Sydney Metro Martin Place Station Precinct - Traffic and Transport Matters Raised

The Department of Planning and Environment and Roads and Maritime Services have raised a number of traffic and transport related matters in relation to Stage 1 SSD DA (17_8351) for the Sydney Metro Martin Place Station Precinct project. Arup, on behalf of Macquarie Corporate Holdings Pty Limited, have prepared the following response to these matters:

Figure 13 Indicative access to new and existing service yards

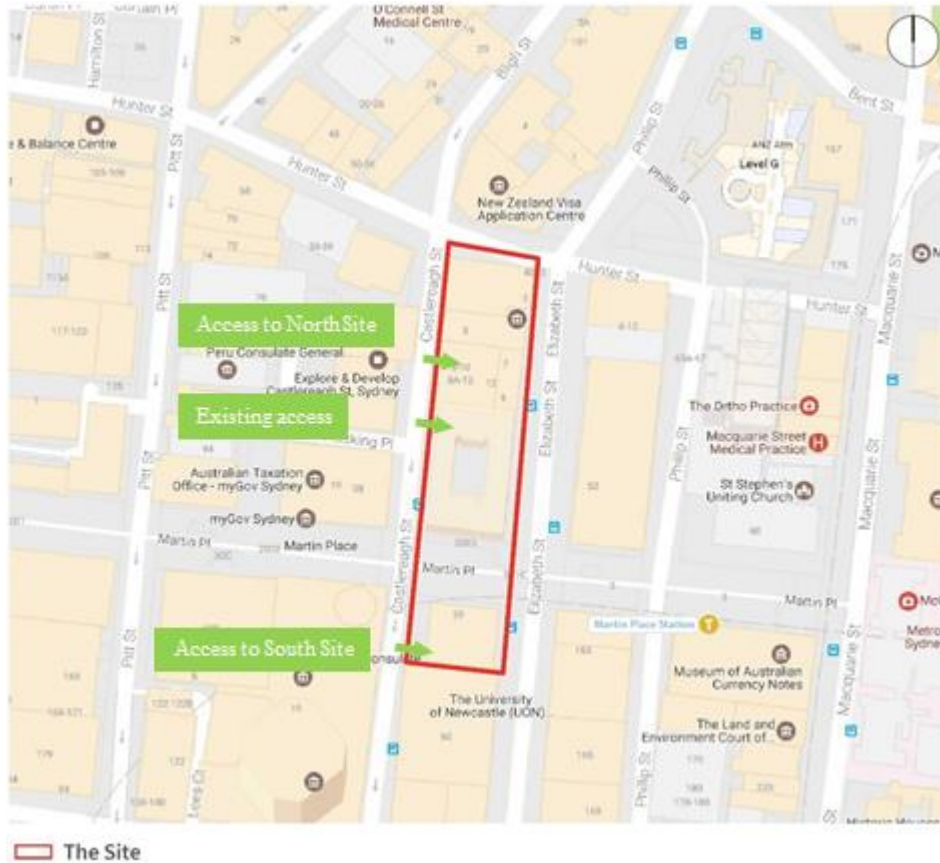
3. *The proposed vehicular access points for the loading dock should be located as far as reasonably practical away from the traffic signal controls on Castlereagh Street.*

4. *All vehicle should enter and exit the site in a forward direction. The swept path of the longest vehicle entering and exiting the development, as well as manoeuvrability through the site, should be in accordance with AUSTROADS. In this regards, a plan shall be submitted to Council for approval, which shows that the proposed development complies with this requirement.*

The loading dock vehicle access is located mid-block between traffic signals on Castlereagh Street to minimise impacts on traffic flow.

Swept paths have carried out based on the current layout which comply with AUSTROADS in terms of accessing the development and manoeuvrability. As part of the Stage 2 DA, swept paths will be provided which clearly show compliance with AUSTROADS requirements.
